WEST SUSSEX COUNTY COUNCIL CONSULTATION

TO:	Arun District Council FAO: Ms M Tomalova
FROM:	WSCC - Highways Authority
DATE:	1 October 2019
LOCATION:	Barnham Court Farm, Church Lane, Barnham, PO22 0BP
SUBJECT:	BN/73/19/PL Change of use of The Little Yard to independent dwelling & the stationing of up to 4 No. Shepherd Huts to be used as tourist accommodation. This application affects a Public Right of Way, may affect the setting of a listed building & affects the character & appearance of the Church Lane, Barnham Conservation Area.
RECOMMENDATION:	Advice

## Site 1 Marl Hole

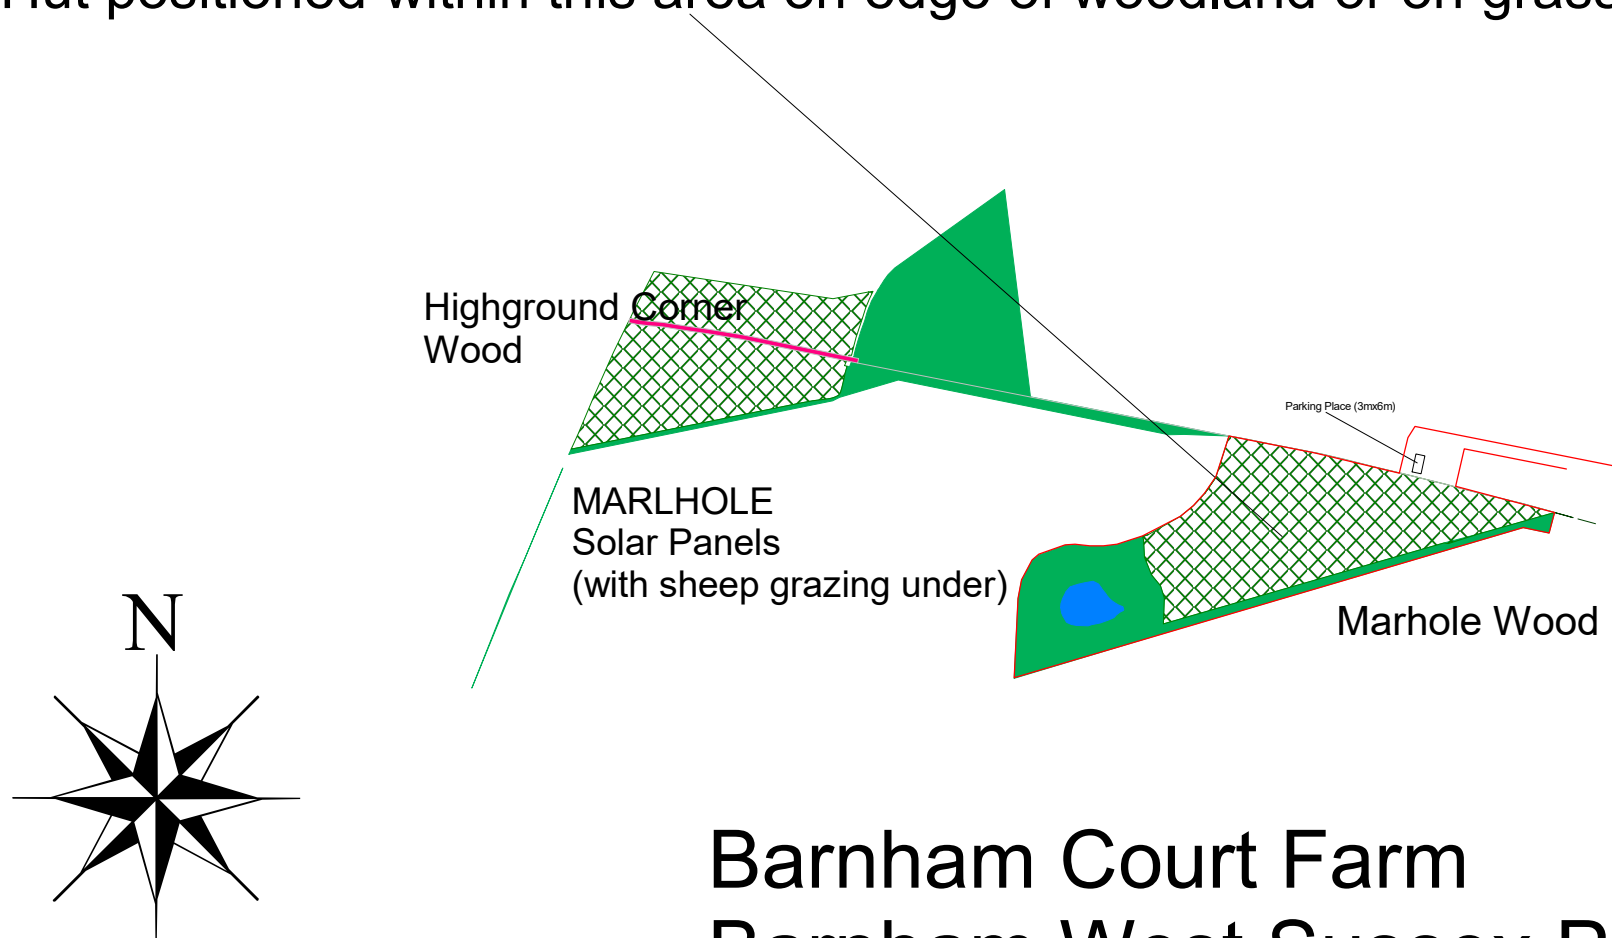
Public Right of Way (PROW) no 200/1 borders the Marlhole Wood site and WSCC PROW team have been consulted separately. The plans indicate a parking space per site, it should be ensured that use of this does not impact on the PROW. The siting of the tourist accommodation units and associated traffic is not anticipated to result in a highway safety or capacity issue to the public highway network.
